District: Cherwell

Application No: 21/01224/OUT

Proposal: Outline planning application for Automotive Experience Quarter comprising Commercial, Business and Services uses (Class E), Light Industrial (Class B2), Local Community and Learning Uses (Class F) and vehicle circuits (Sui Generis) with all matters reserved aside from that of access).

Transport Development Control

job title: Bicester Motion  
 Brand Experience Application  
 drawing title: Proposed Access

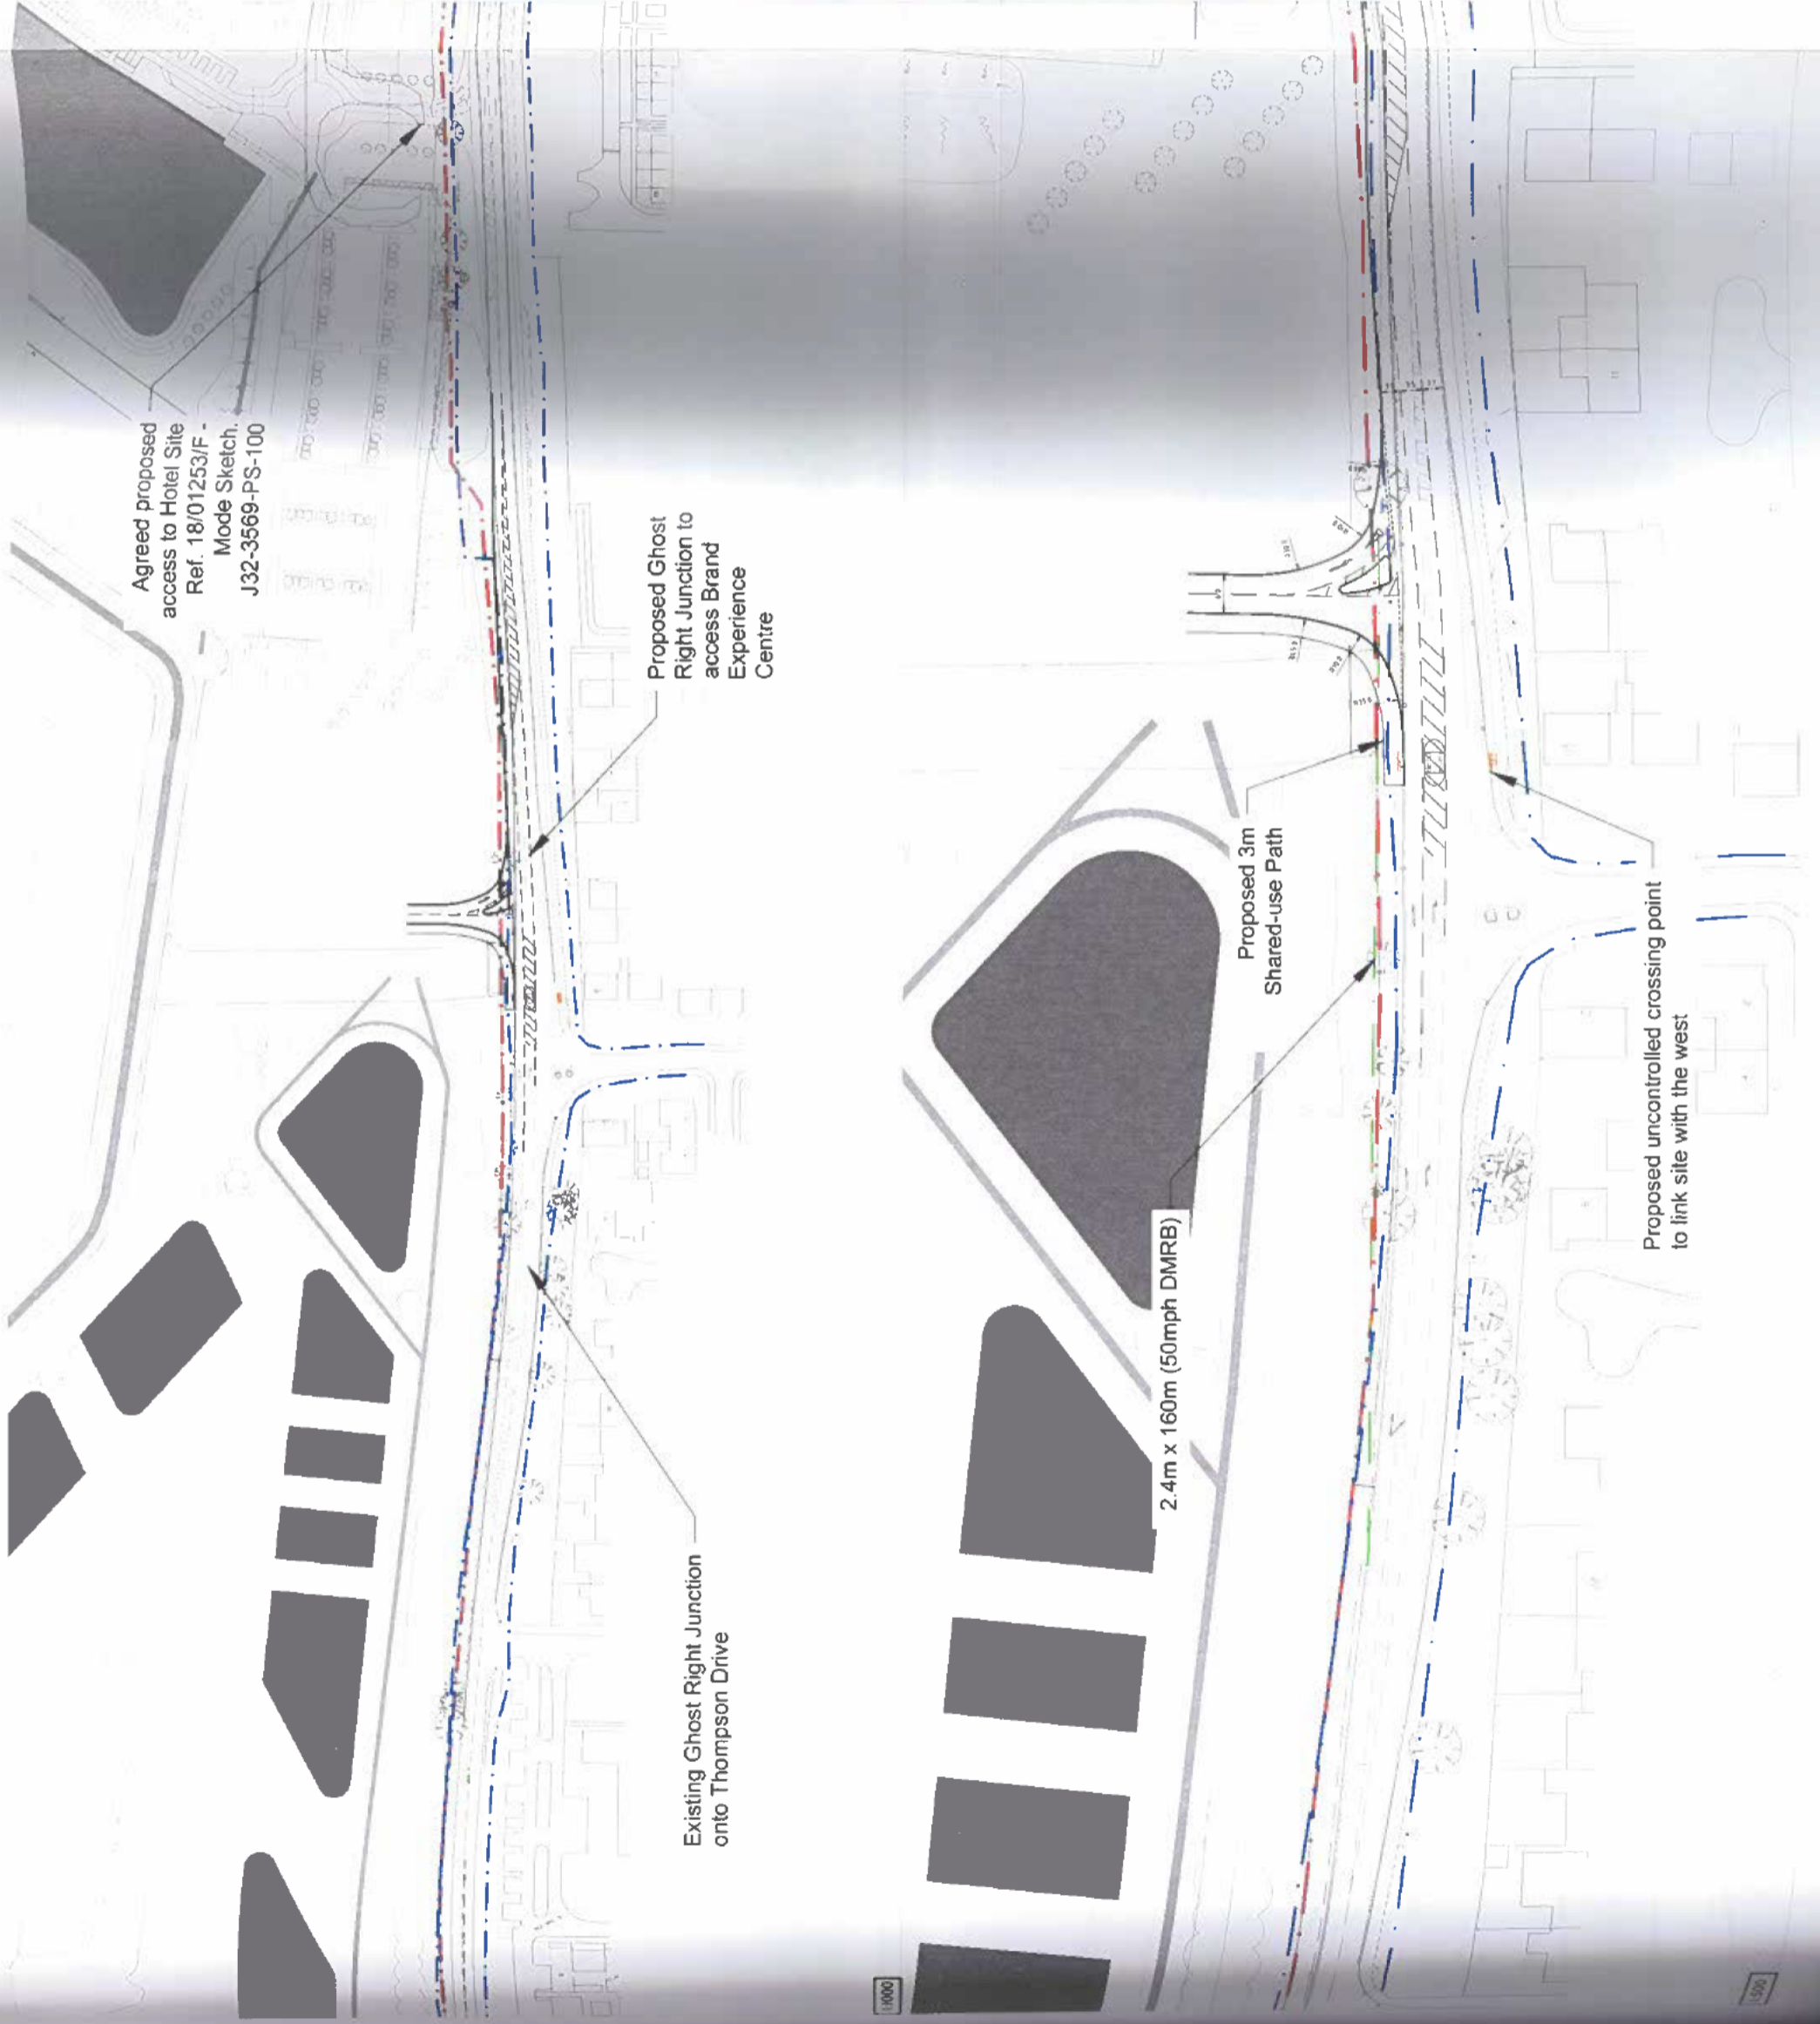
A swept path analysis has been submitted which demonstrates that a 12m rigid vehicle would be able to safely enter and exit via the two access junctions. However, it is unclear whether any larger vehicles (e.g. refuse vehicles) could be accommodated these junctions, the vehicle tracking is fairly tight at the primary access junction. The note states that a 12m rigid vehicle is expected to be the largest vehicle required to access the site, so it is assumed that refuse collections from Bicester Motion will be using smaller than average refuse vehicles. A planning condition is requested to ensure that the detailed layout of the primary access junction is agreed prior to commencement of development.

- Site access junction from the A4421 Buckingham Road as shown indicatively in Drawing No. J32-3684-PS-201. Pedestrian and cycle facilities, connections and crossings at the site access junction to be agreed with OCC.
- Improvements to / reinstatement of the site access junctions along Bicester Road (to Stratton Audley) including safe pedestrian and cycle access. To be agreed with OCC.
